Reference: 14.289r03v03

3 November 2016

**Re: The Terraces - Seniors Living and Residential Aged Care Facility
74 Brown Street, Paddington
Removal of Significant Trees 5 and 130**

Attachment D: Site Establishment - Stage 1 (PM-P-2002, Rev 3)

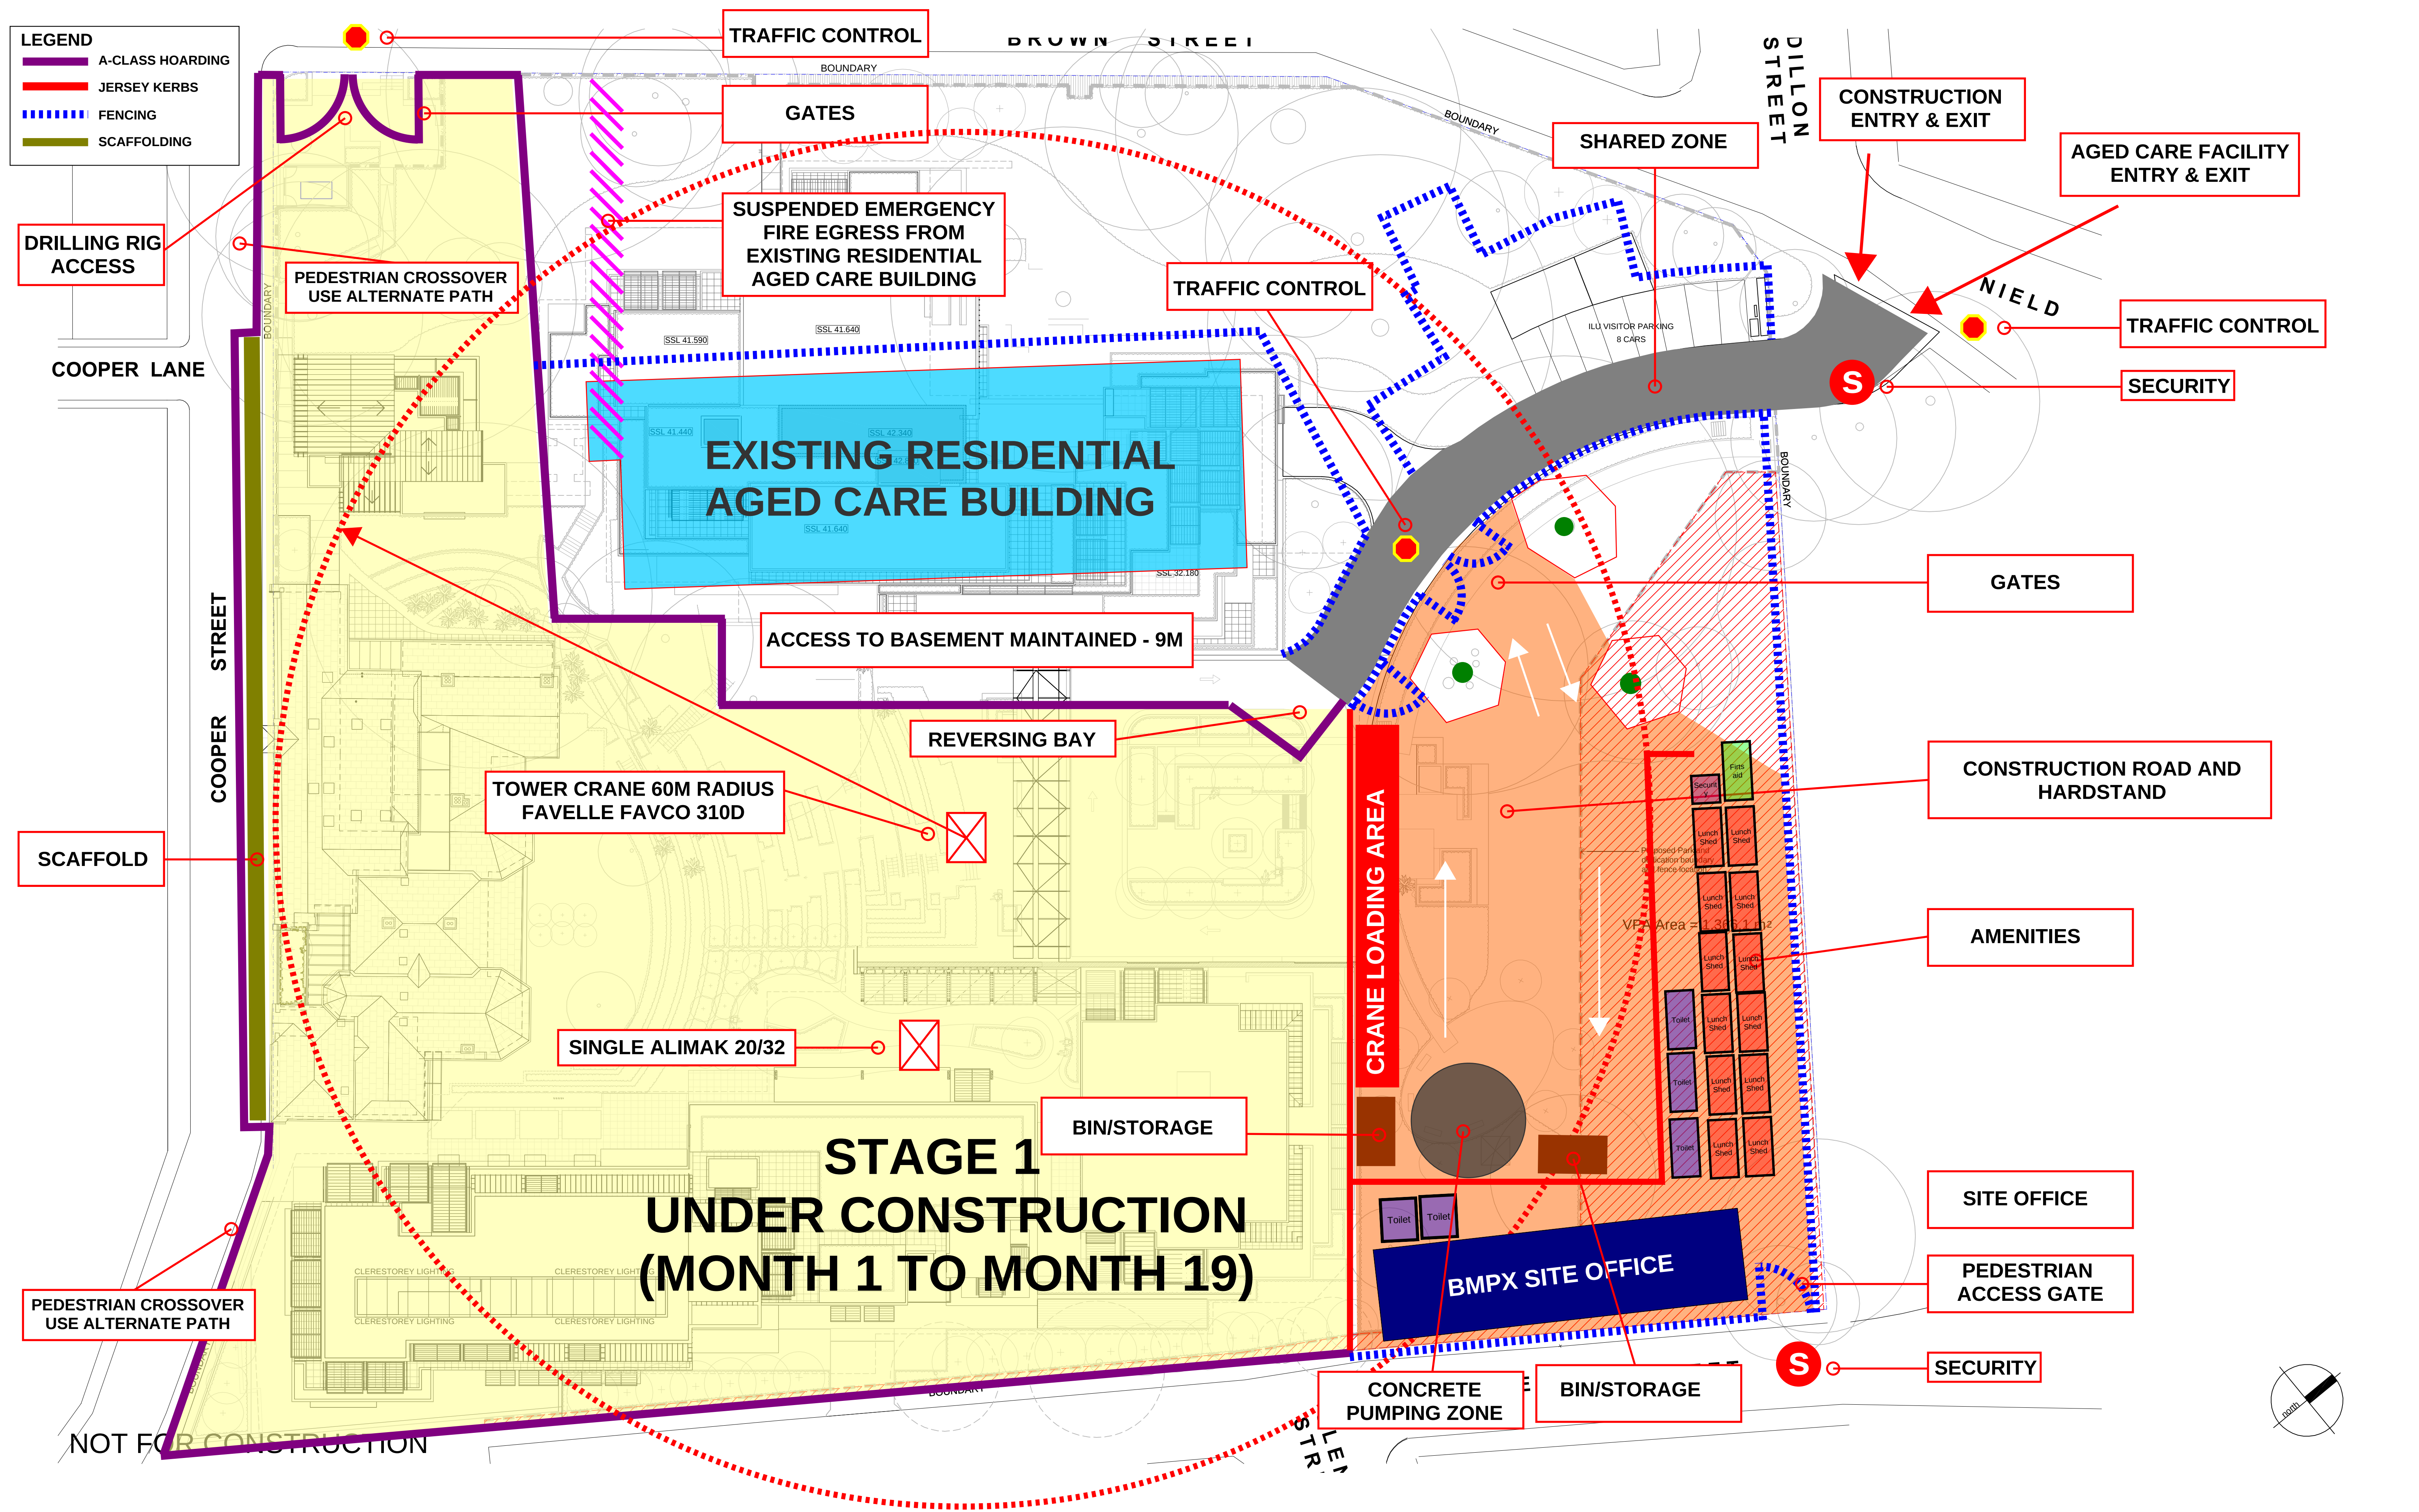
- The internal arrangements would not permit trucks to satisfactorily turn around within the site, ensuring that they could exit the site in a forward direction. Forward entry and exit manoeuvres to the site are essential for both safety and efficiency reasons, as well as being a requirement under Condition B7 of the development approval (MP10_0016). Specifically, reverse manoeuvres would most likely be required from previously proposed Gates 5, 6 and 7.

- The change in levels between the street and hardstand at the previously proposed Gate 5 is approximately 1.2m. This is considered a significant grade that trucks would need to reverse up in order to exit the site, which is considered unsafe. This would also result in efficiency concerns along Brown Street as through traffic would need to be held by traffic controllers each time a truck exits the site.

- The construction access driveway at the previously proposed Gate 5 would be situated in a prohibited location having regard for Figure 3.1 of AS 2890.1 (2004), rendering it unsafe.

Taking the above into consideration, it is our view that Tree 5 should also be removed to ensure construction vehicles are able to safely and efficiently enter and exit the site in a forward direction, as would be allowable through the implementation of the Option A site access and internal traffic circulation arrangements.
